**The Examining Authority's Written Questions
Issued on 21 April 2021**

**Answers from the
Royal Society for the Protection of Birds
and Suffolk Wildlife Trust**

**Application by NNB Generation Company (SZC) Limited for an Order
Granting Development Consent for
The Sizewell C Project**

**Planning Inspectorate Ref: EN010012
RSPB Registration Identification Ref: 20026628
Suffolk Wildlife Trust Registration Identification Ref: 20026359**

DRAWING NO:
SZC-SZ0100-XX-000-DRW-100205

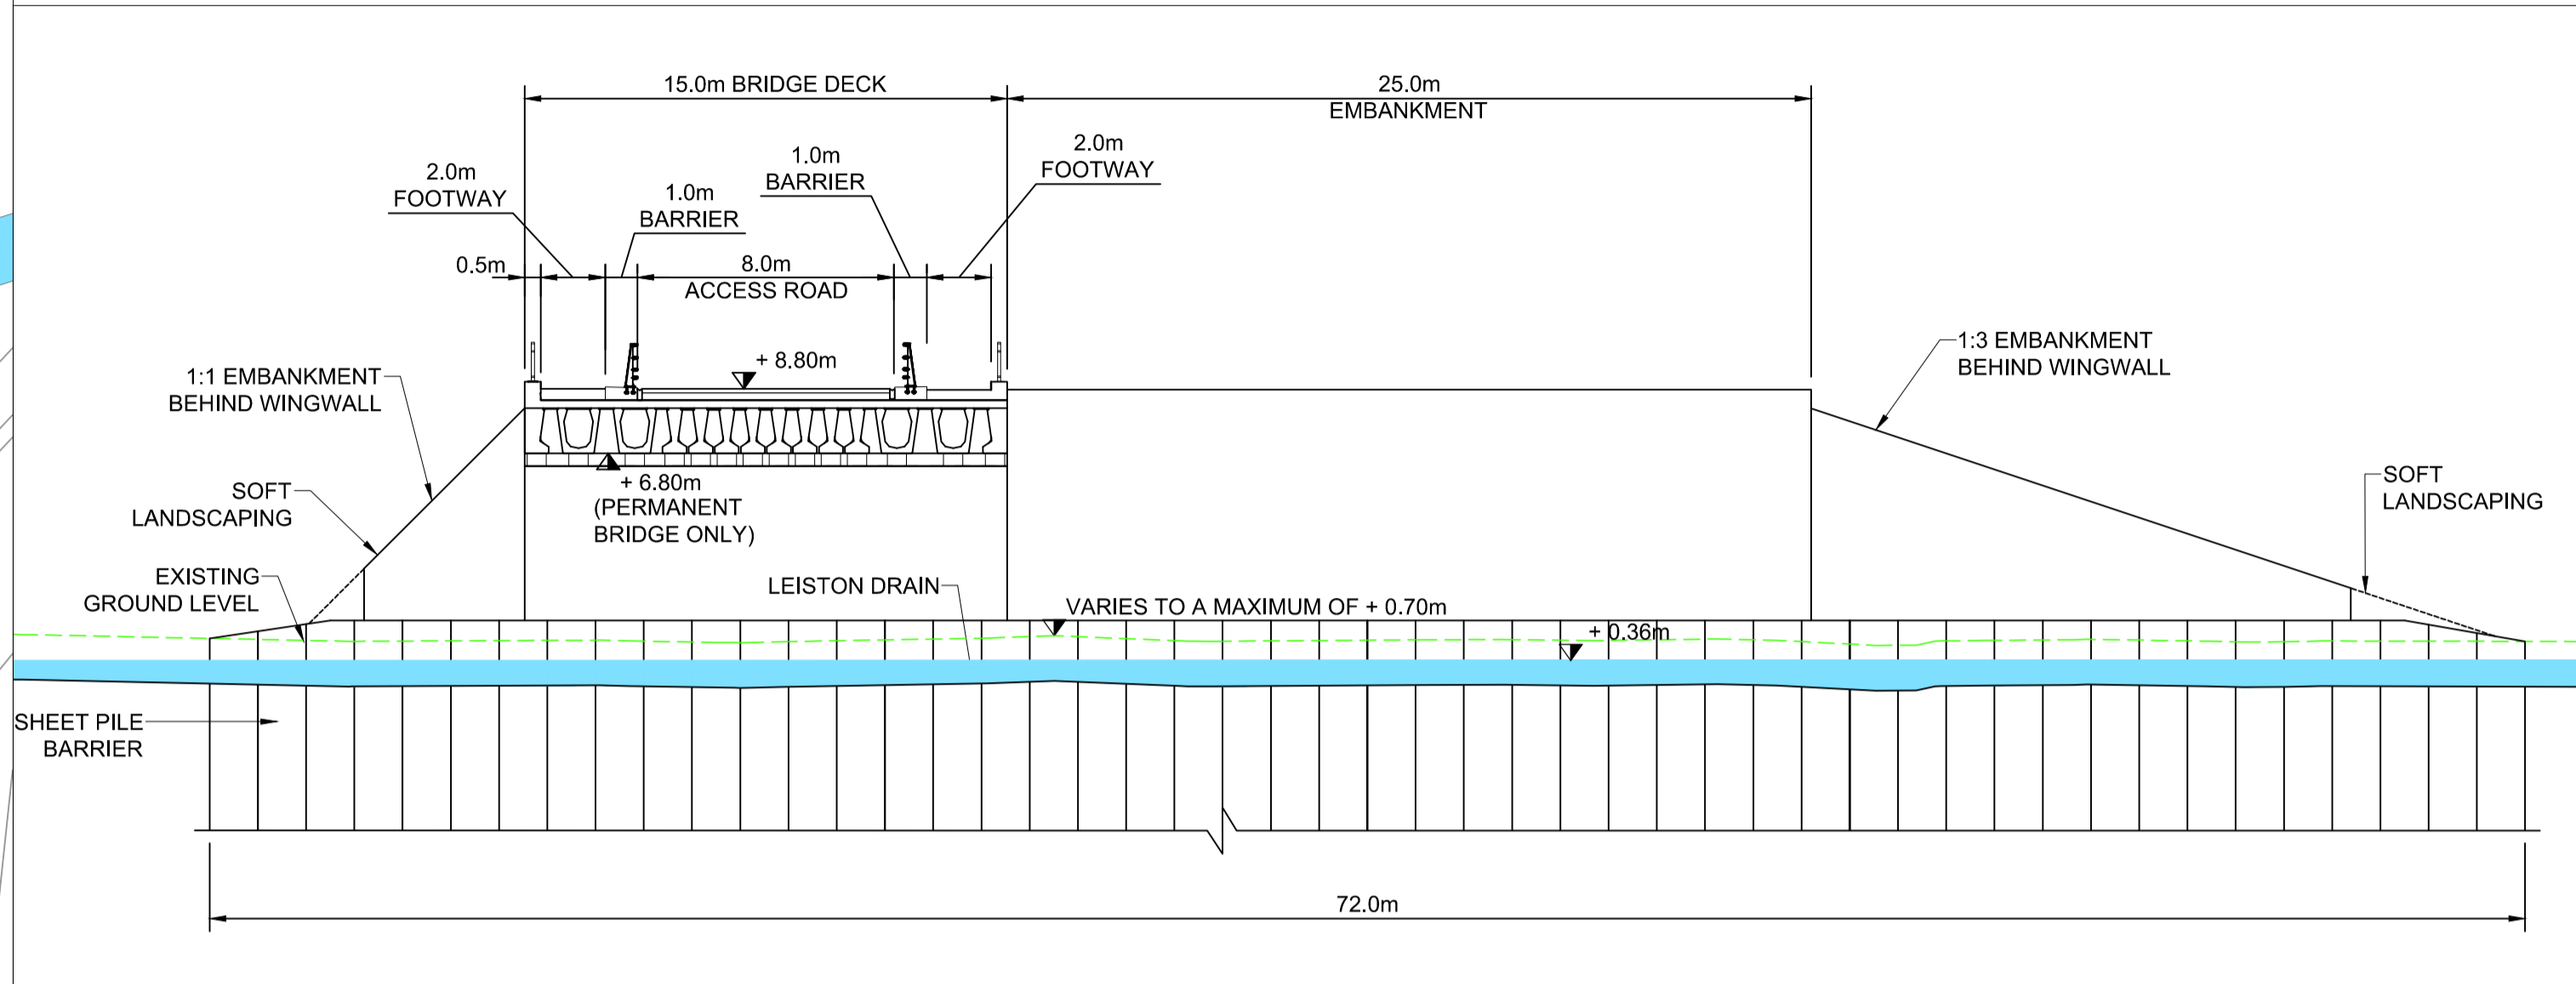
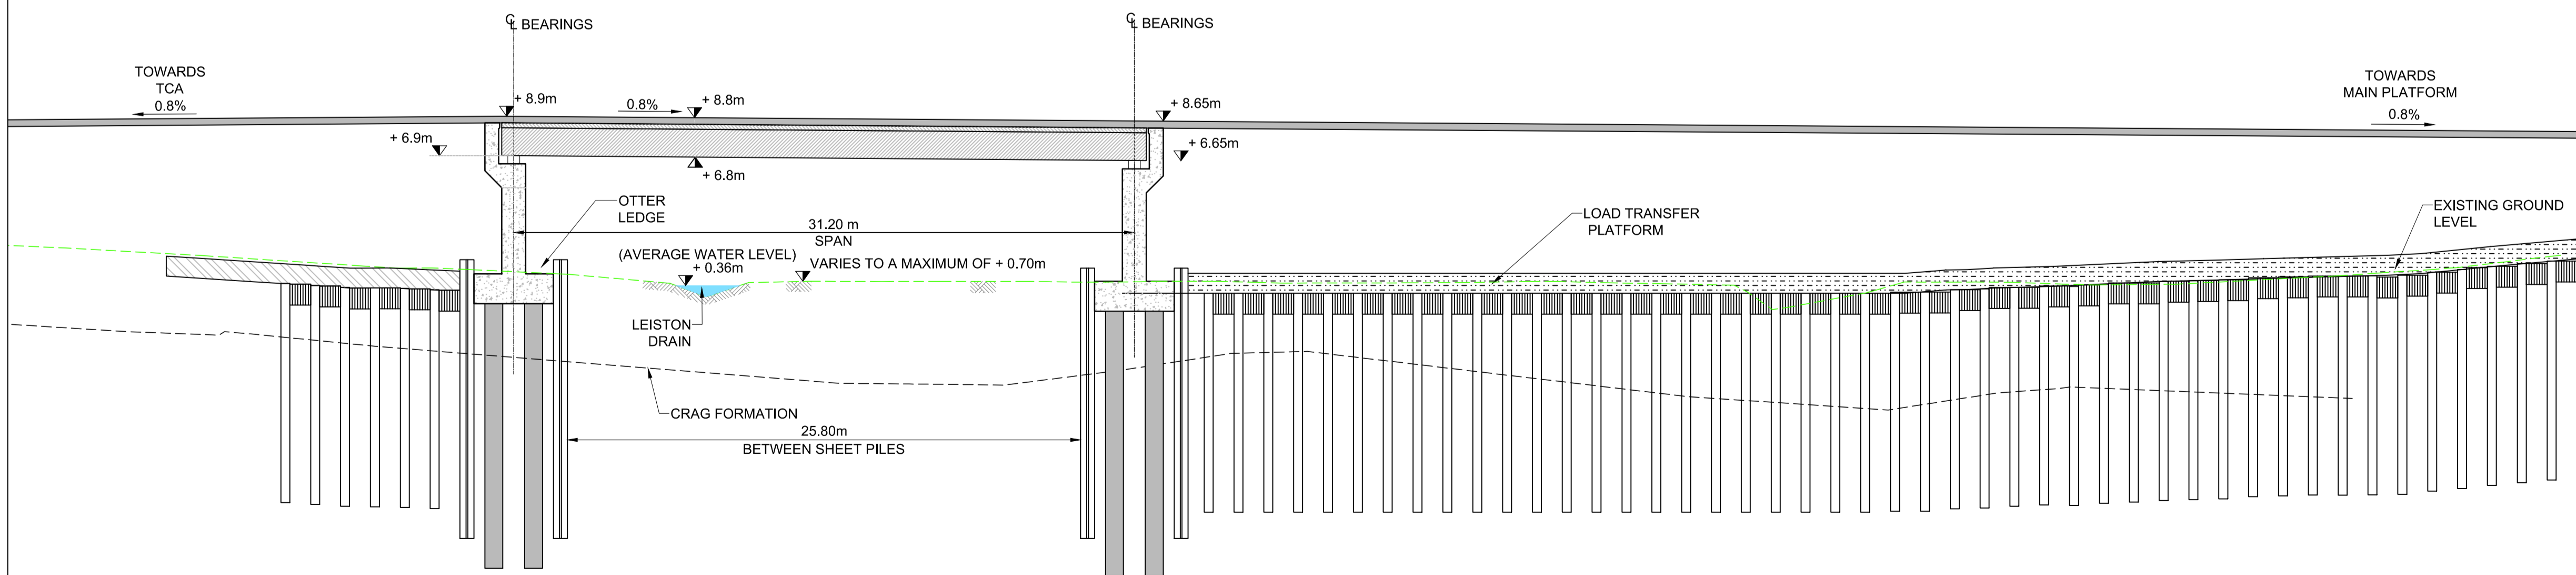
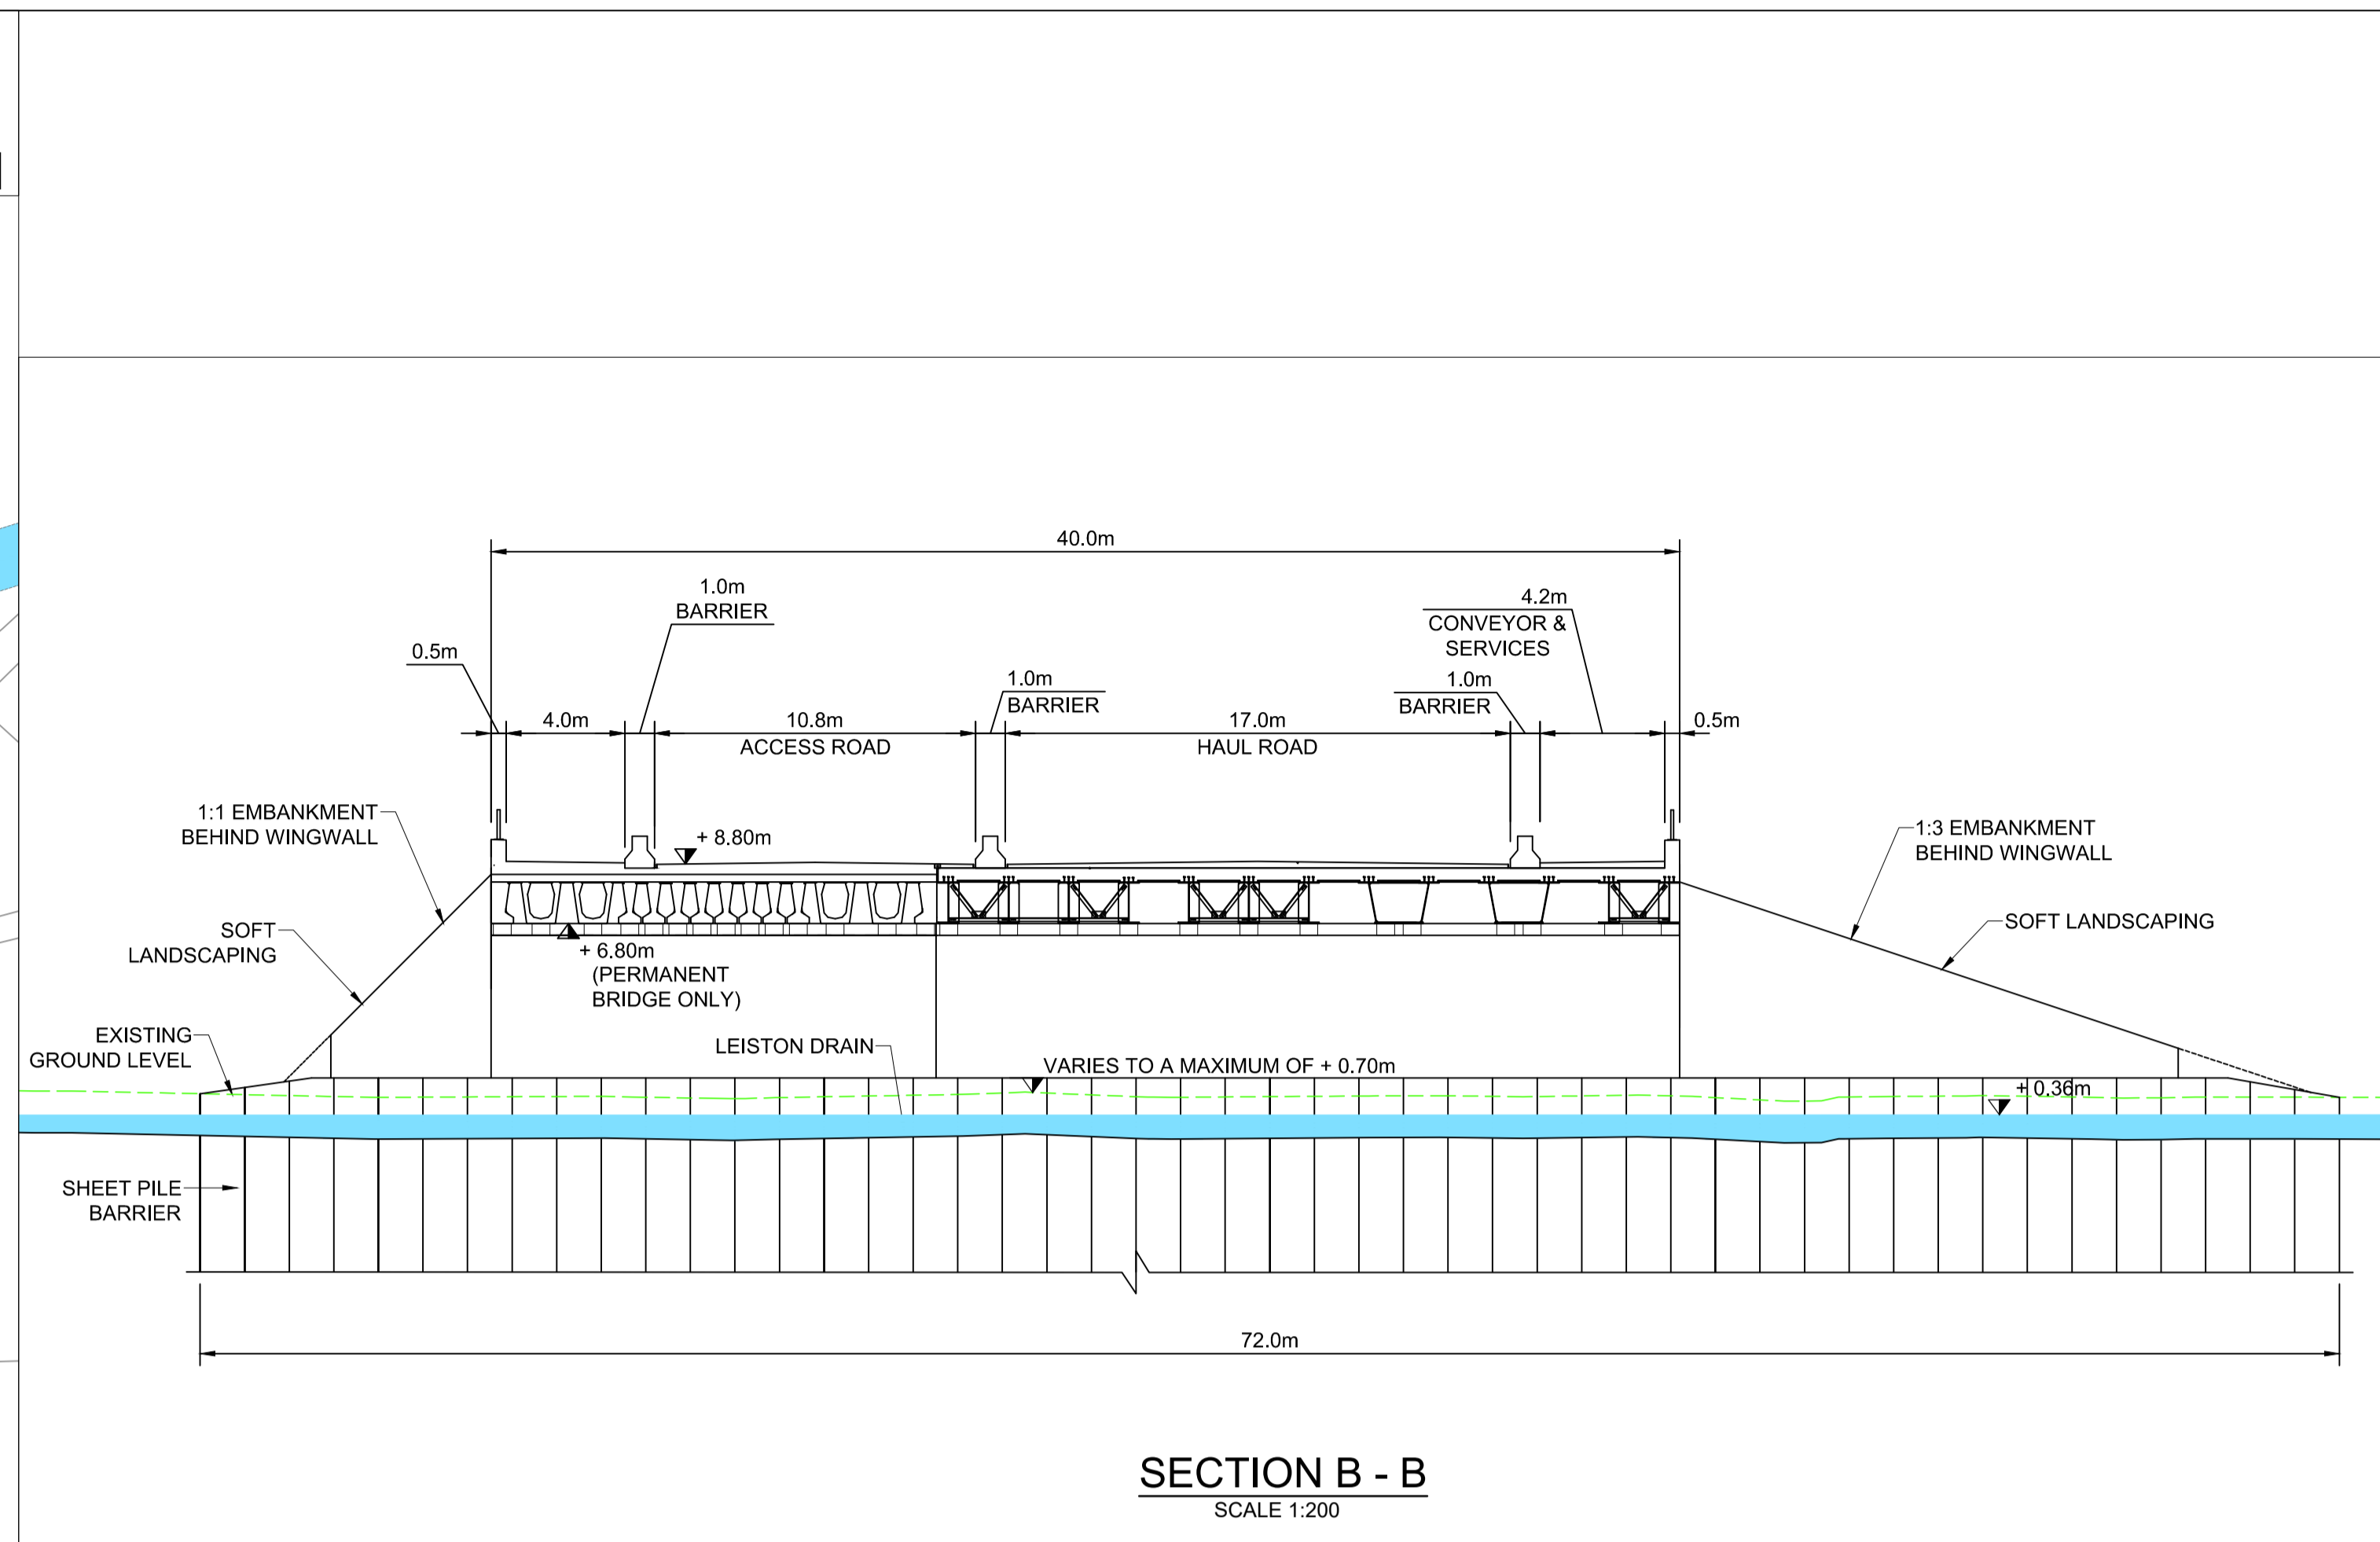
[APP-224] – para 14.7.227, hydrology and the effect of the SSSI Crossing.

However, we refer to the report commissioned by Friends of the Earth and Suffolk Wildlife Trust titled 'A critical review of Sizewell C Co's site characterisation, impact assessment, and proposals for impact mitigation, in relation to risks posed to the ecohydrological integrity of Sizewell Marshes SSSI⁵.' which illustrates the risk to the SSSI is largely due to changes in the balance between groundwater and surface water. Many of the rare species rely on high quality groundwater rising up through the peat. The proposals put forward may maintain water levels, but by replacing groundwater with lower quality surface water. It is important to note that these changes may be caused not only by the SSSI crossing but also by the footprint of the development itself.

9. There are three major developments that have the potential to have a major impact on the sensitive ecohydrological functioning of the wetland system. These are:
 - The new cut-off wall adjacent to the platform base for the new site, and related internal lowering of groundwater levels (dewatering) during the construction phase;
 - The re-routing of the Sizewell Drain; and
 - The new crossing at the drainage outlet for the Sizewell Drain and the Leiston Drain.

11. A free span bridge would be far less impacting, as it would leave a significantly wider corridor unchanged, to facilitate original hydraulic control and subsurface drainage of the SSSI site.
